Tillbridge Solar Limited  
111 Park Street  
Mayfair  
London  
United Kingdom  
W1K 7JF

18 July 2024

## **APPLICATION BY TILLBRIDGE SOLAR LIMITED FOR A DEVELOPMENT CONSENT ORDER FOR THE TILLBRIDGE SOLAR PROJECT**

### **NOTIFICATION OF INTENTION TO SUBMIT A REQUEST TO CHANGE THE APPLICATION**

Sheet Title
 STREETS, RIGHTS OF WAY AND ACCESS PLANS
 SHEET 7 OF 24

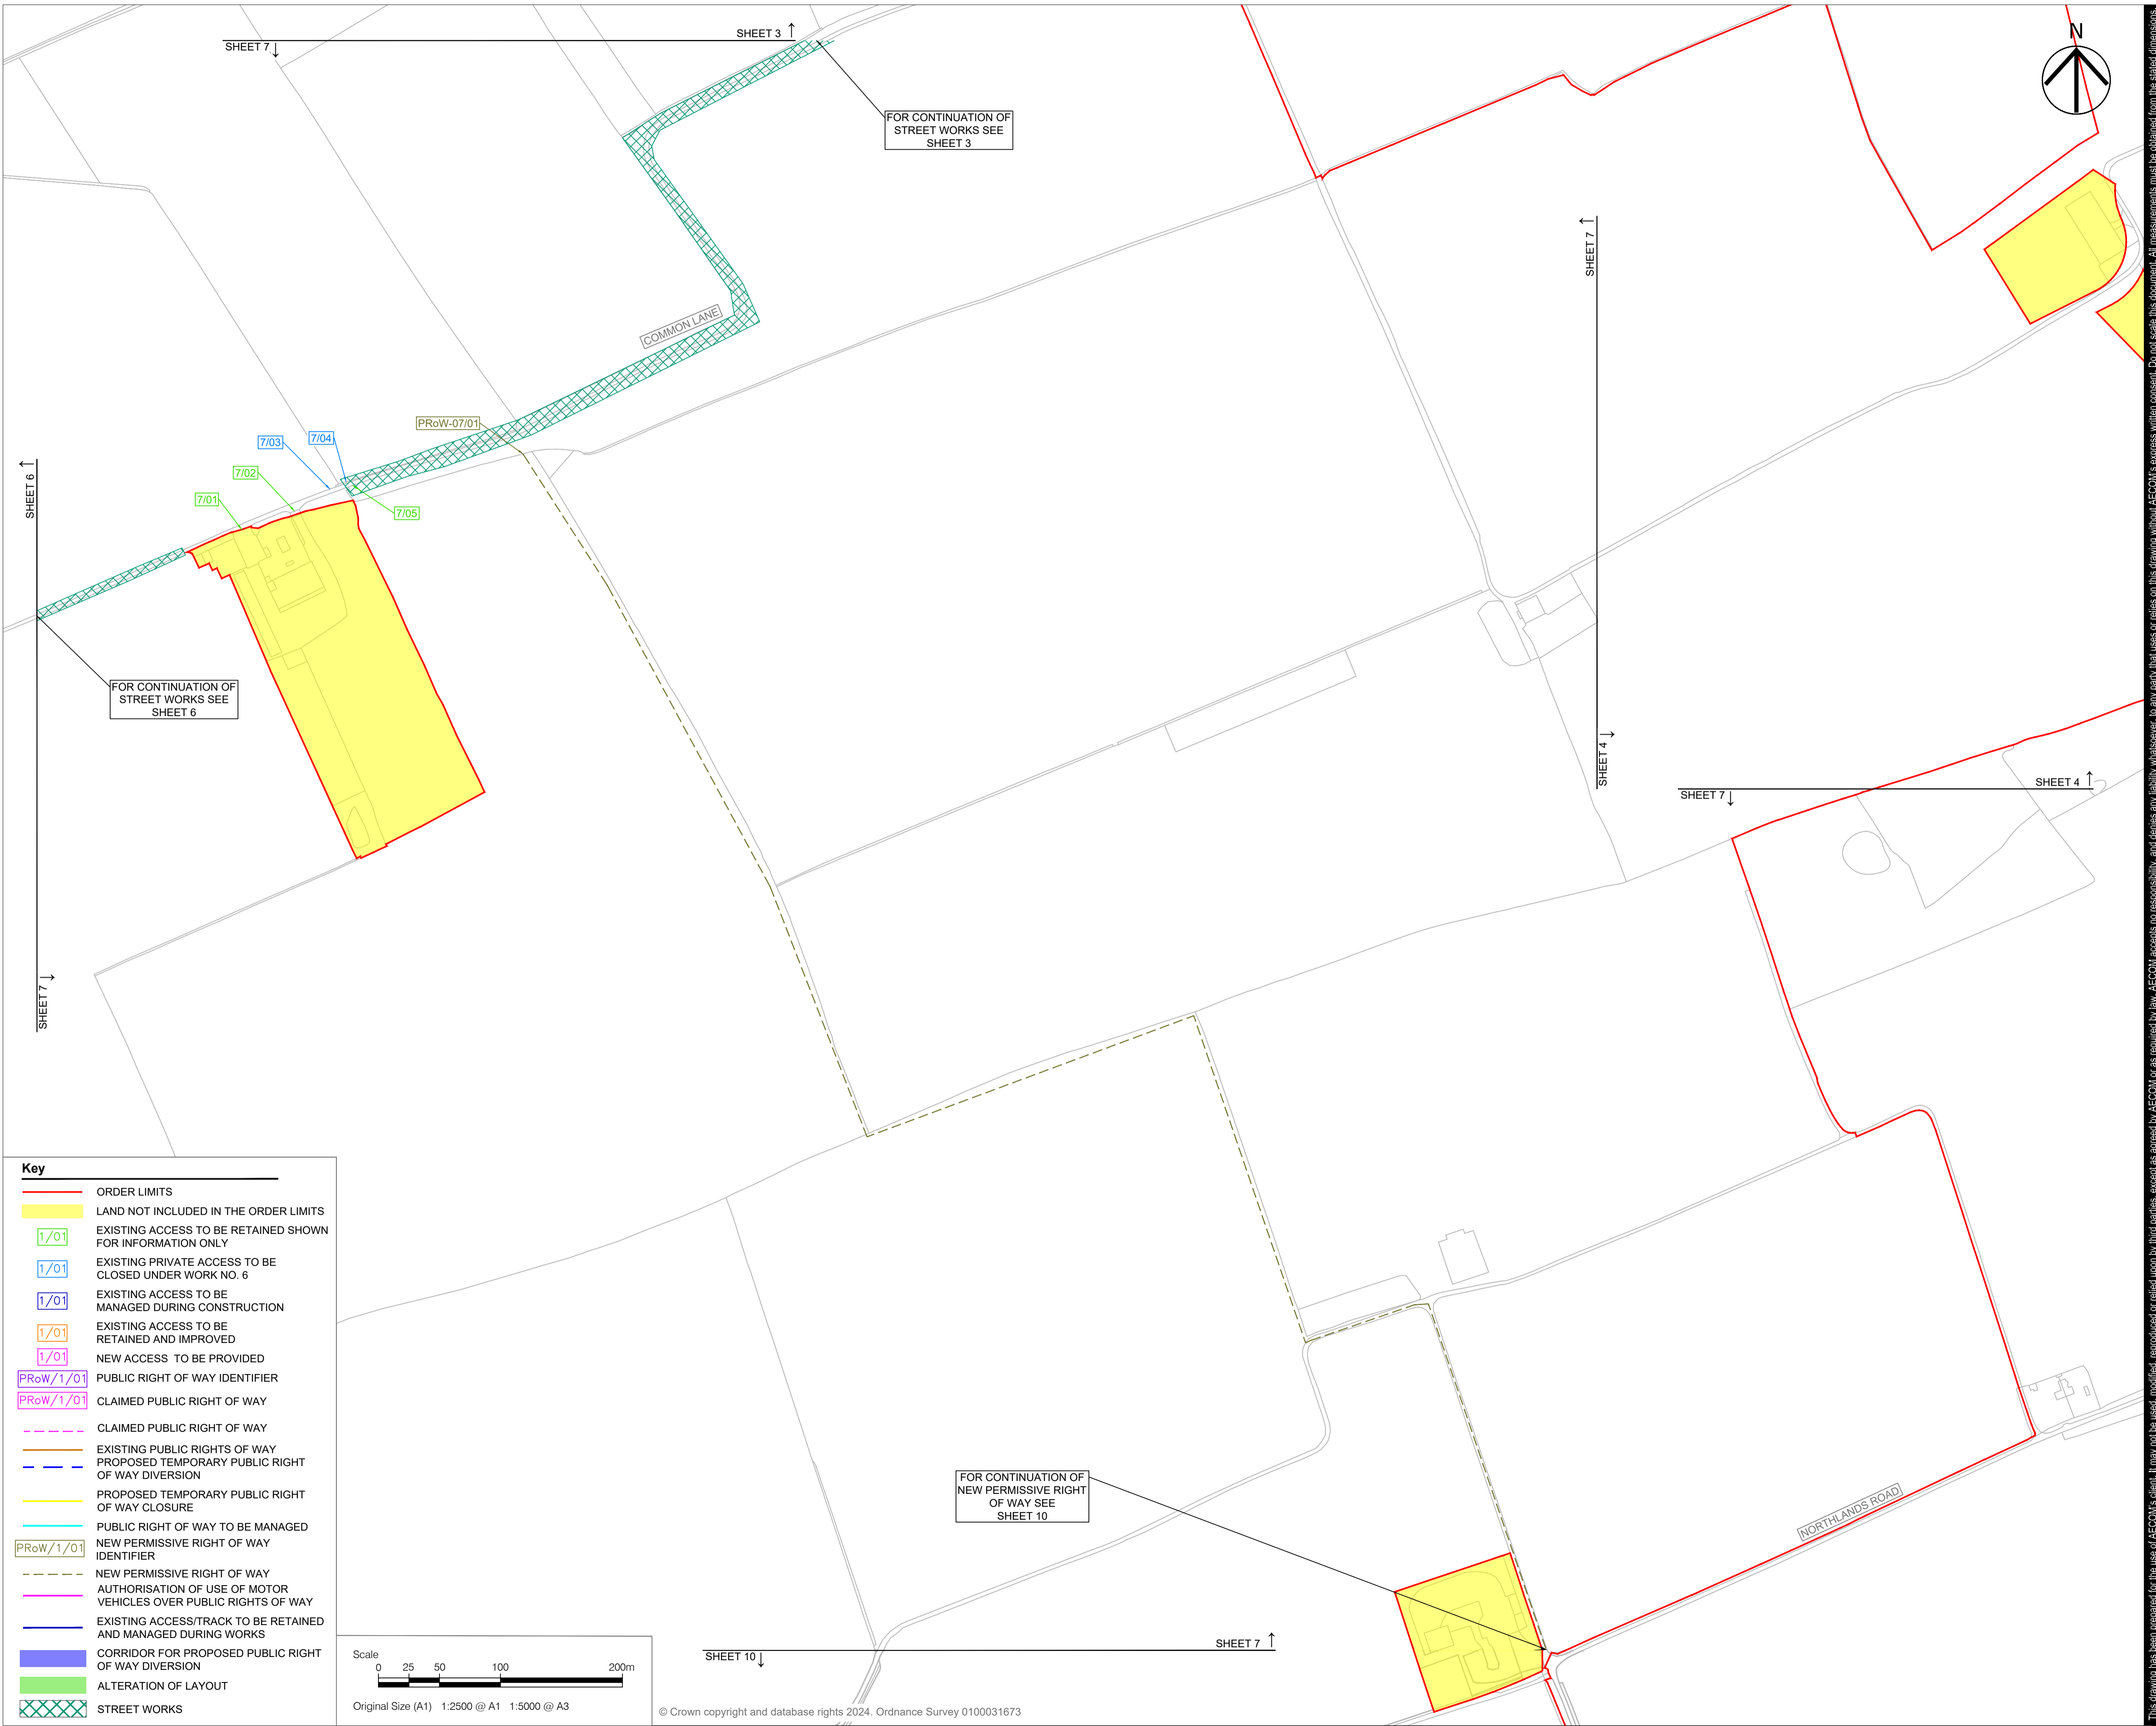
***Change 6: Removal of Highway Extents from Order limits along Northlands Road and Kexby Road.***

This change will result in the removal of highway extents along Northlands Road and Kexby Road as shown on Sheet 10 and 7 of the **Work Plans [APP-007]**, which the Applicant has determined are no longer required for access. The area of land included within the Order limits at this location would reduce as a result of the change.
